SSD 6010 – One Residential Building (Student Accommodation) within Darling Drive

Submission by:

Popo Hartopo and Bradley Garland

SHADOW DIAGRAMS: PERSPECTIVE, SHOWING THE PEAK, WINTER SOLSTICE

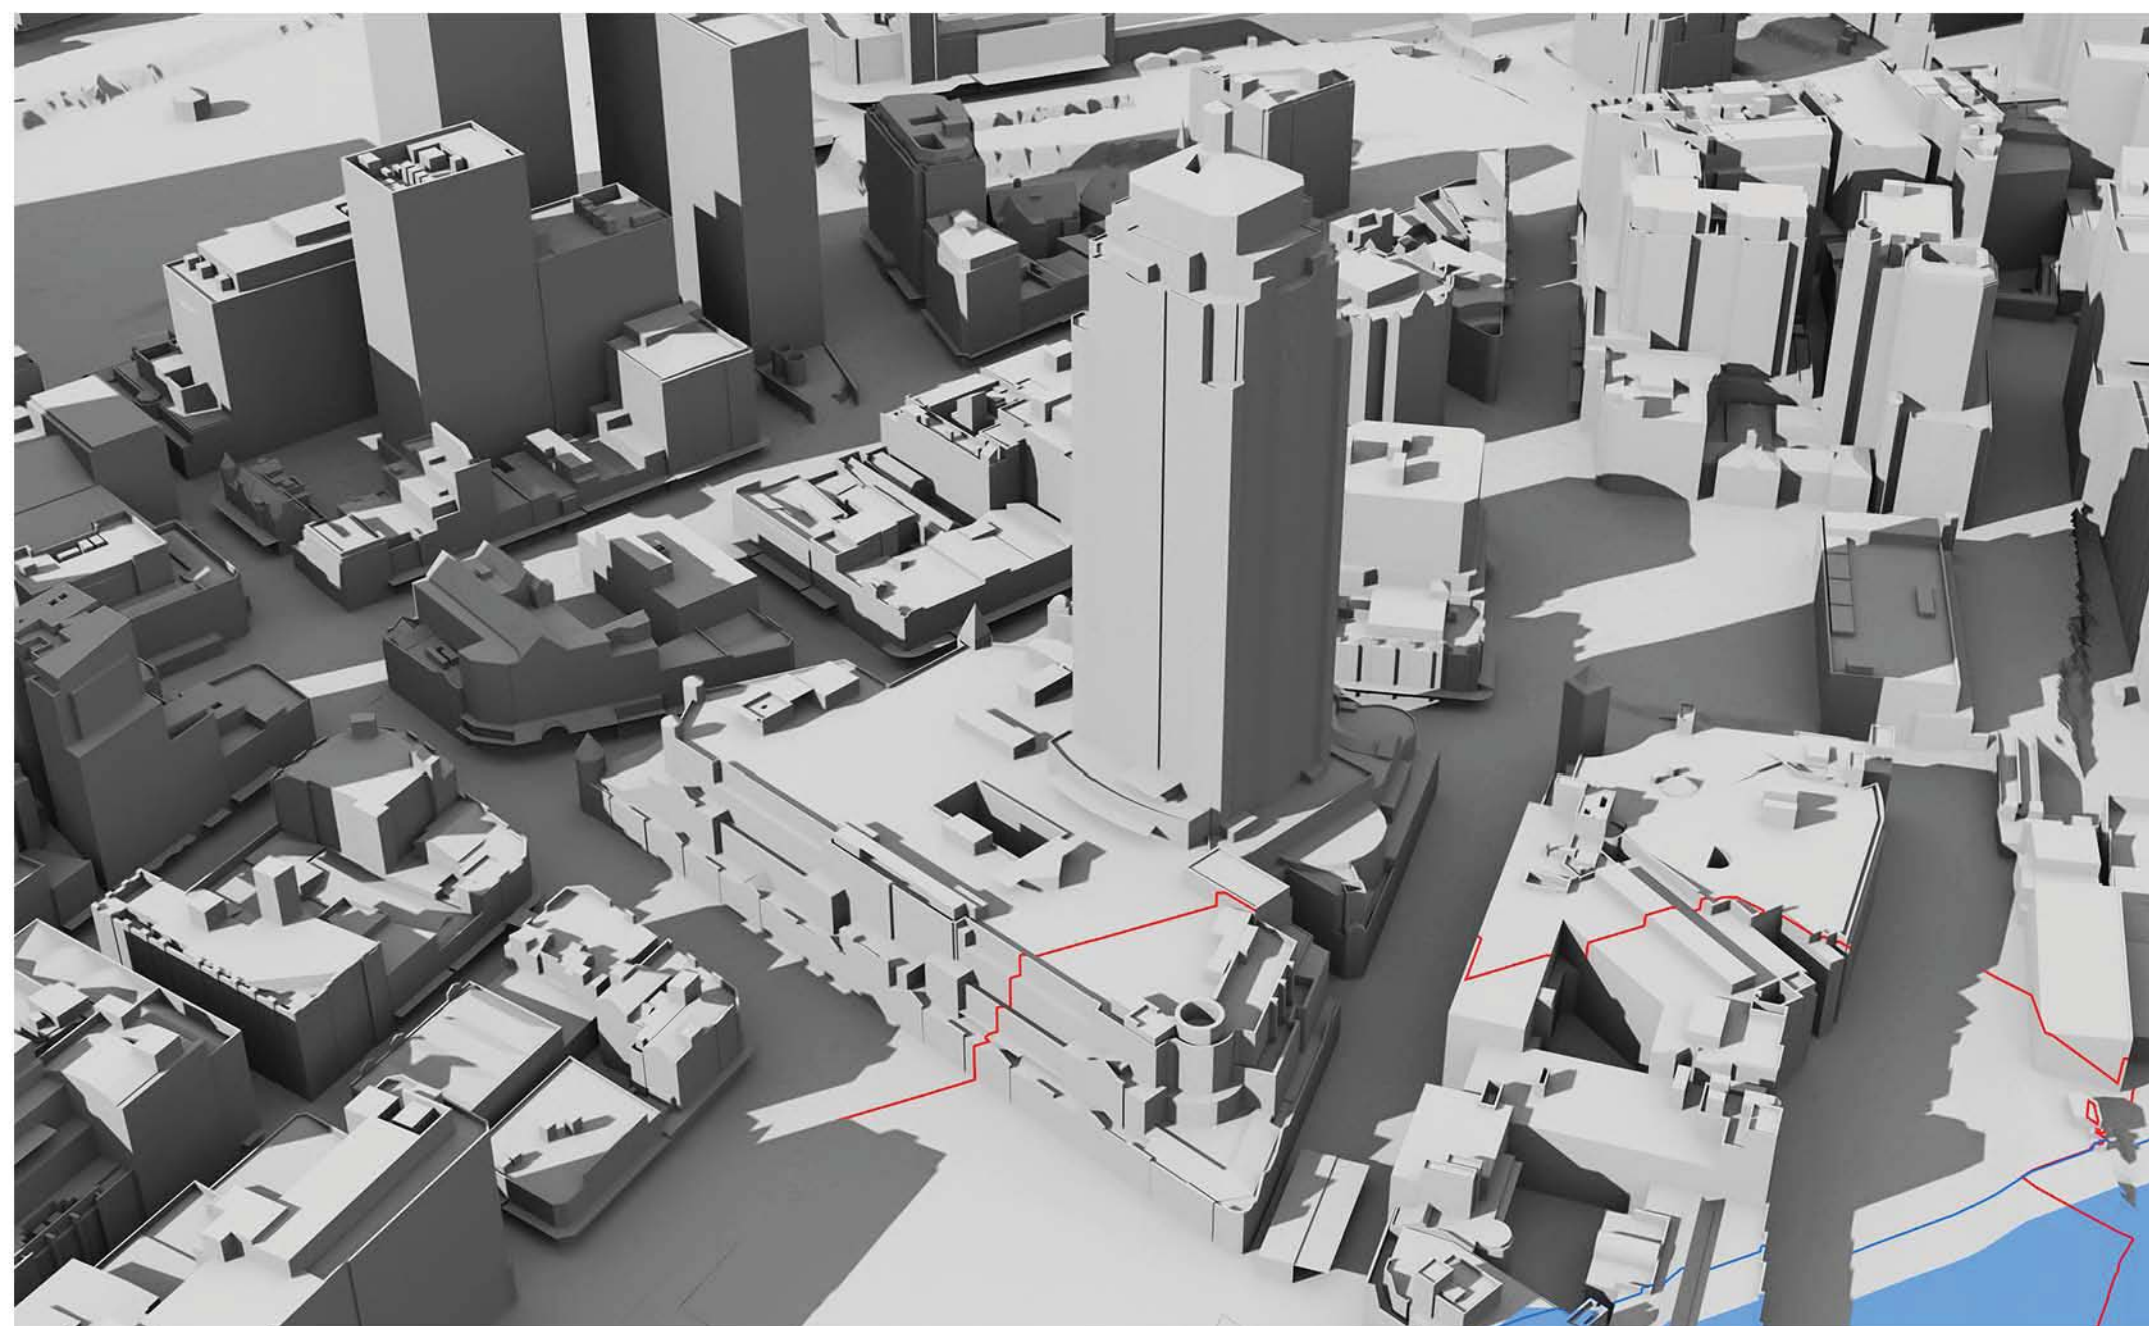
At 9am, 10am and 11am the west façade is totally in shadow due to other parts of The Peak building itself.

At 12pm there is still substantial existing shadowing on the west façade caused by the irregular shape of the west facade.

At 1pm the existing shadowing has been substantially removed, but not totally removed.

It can be concluded that some single aspect apartments on the west façade and some south-west dual aspect corner apartments currently receive less than 2 hours direct sunlight to habitable rooms and 50% of the private open space between 9am and 3pm on 21 June.

At 9am, 10am and 11am the west façade is totally in shadow due to other parts of The Peak building itself.

At 12pm there is still substantial existing shadowing on the west façade caused by the irregular shape of the west facade.

At 1pm the existing shadowing has been substantially, although not entirely, removed. However, overshadowing of lower levels of the west façade by the concept proposal parameter plan shadows for the N,NE and SE plots has already started.

By 2pm the existing shadowing has been totally removed. However, overshadowing of the west façade by the SSDA4 and SSDA5 buildings has appeared and risen further up the west façade than the concept proposal parameter plan shadows for the N,NE and SE plots, which is still present.

At 3pm, the proponent states correctly that 45-45% of the western façade is overshadowed by the SSDA4 and SSDA5 buildings.

It can be concluded that, as a result of combination of the proposed development with existing shadowing of the west façade, some single aspect apartments on the west façade and the south-west dual aspect corner apartments which currently receive less than 2 hours direct sunlight to habitable rooms and 50% of the private open space between 9am and 3pm on 21 June will suffer additional overshadowing. It is beyond our skills to count the number of such apartments. We note that the proponent has made no attempt to do so.

Rather than counting the number of units which will not meet the DCP guidelines, the proponent attempts to trade-off direct sunlight at 4pm for lack of direct sunlight during the period 9am to 3pm. There is no provision in the DCP guidelines for such a trade-off.
